Please ask for: Ms Iqraa Malik
Email: iqraa.malik@terraquest.co.uk
Telephone: 01212341390
Our Ref: BR/207/20/HH
Your Ref:
Date: 1st October 2020

Application for Planning Permission for Works or Extension to a Dwelling

Development: Rear Extension and modified conservatory
Location: 25 Havelock Road Bognor Regis PO21 2EZ

25 Havelock Road PO21 2EZ - Block Plan

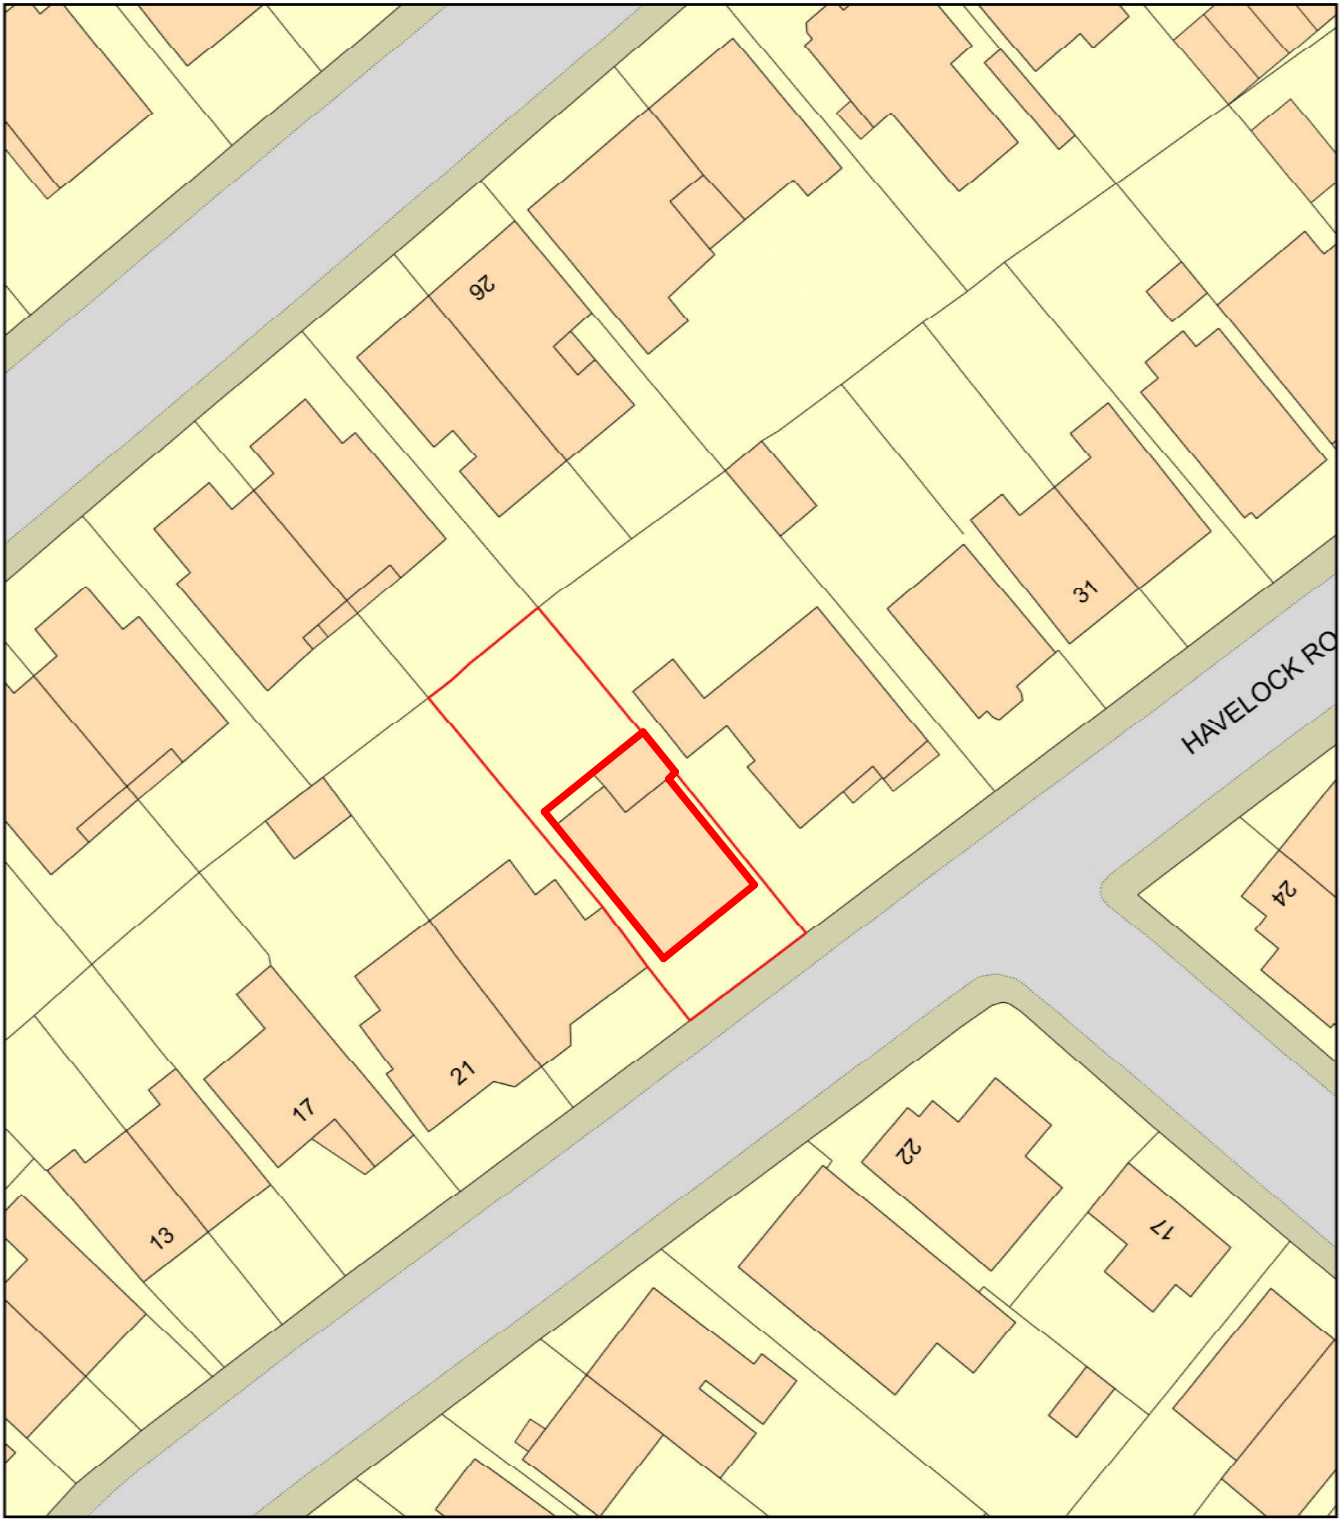
Please submit a copy of a proposed block plan with dimensions from the proposed extension(s) to all site boundaries at a scale of 1:500. Further details of what must be included on the plan can be found in the Validation Requirements List.

All plans: The 1:500 scale bar on your plans does not measure to scale. Please amend.

25 Havelock Road PO21 2EZ - Location Plan

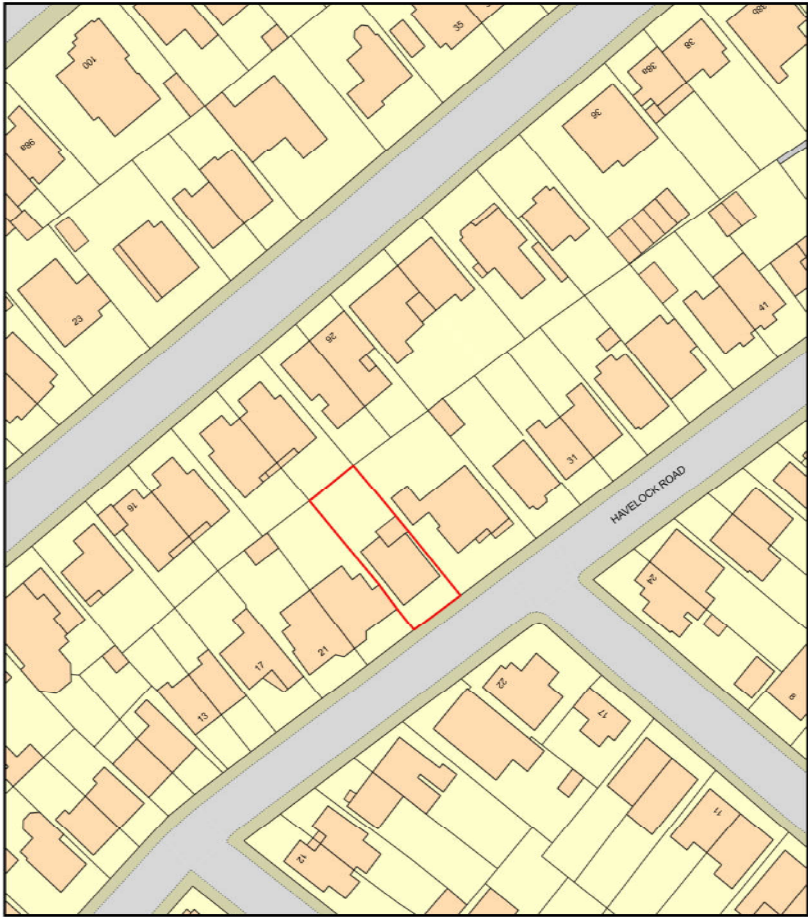
Please submit a copy of a location plan at a scale of 1:1250. Further details of what must be included on the plan can be found in the Validation Requirements List.

PROJECT 25 Havelock Road PO21 2EZ	CLIENT Widt Nielson		
	Date	Issue Date	Scale (@ A3) 1 : 100
SHEET N&S Elevations	Drawn by SW	DRAWING NUMBER P103	REV
	Checked by SR

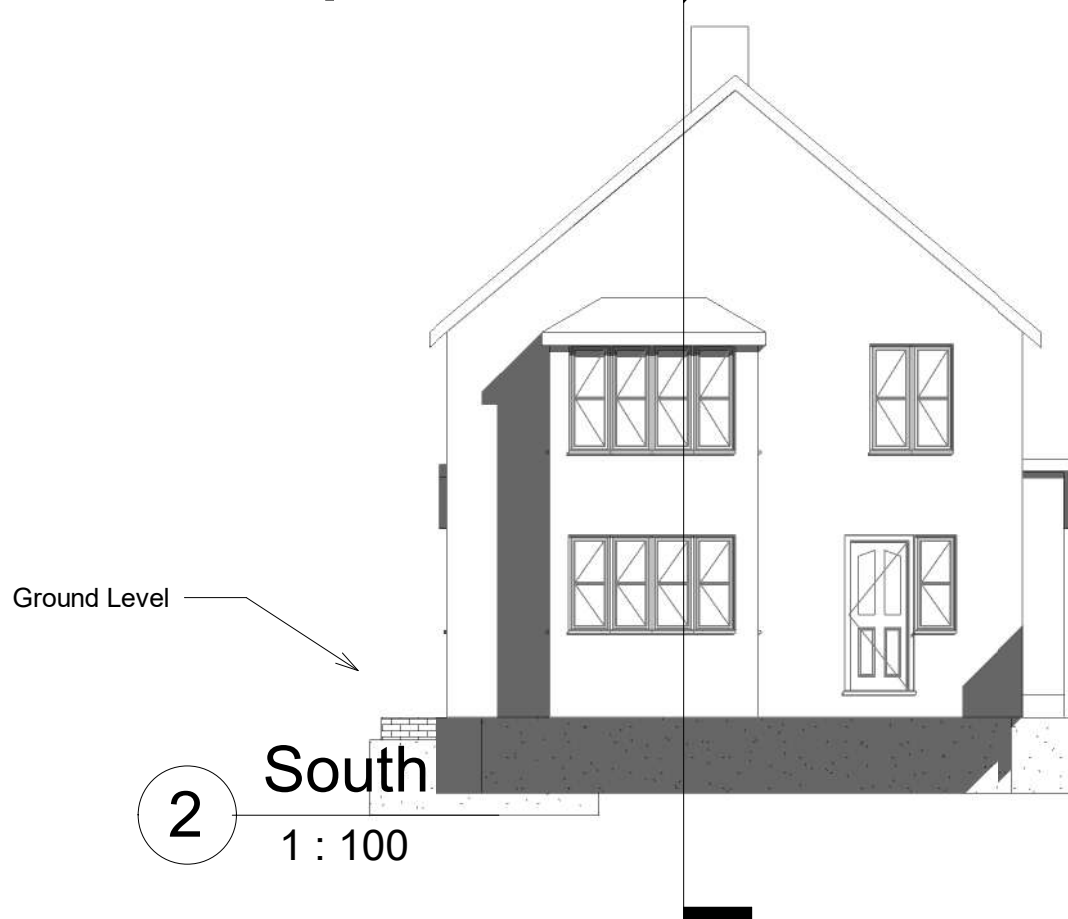
Please submit a copy of clearly labelled existing and proposed elevations at a scale of 1:50 or 1:100. Further details can be found in the Validation Requirements List.
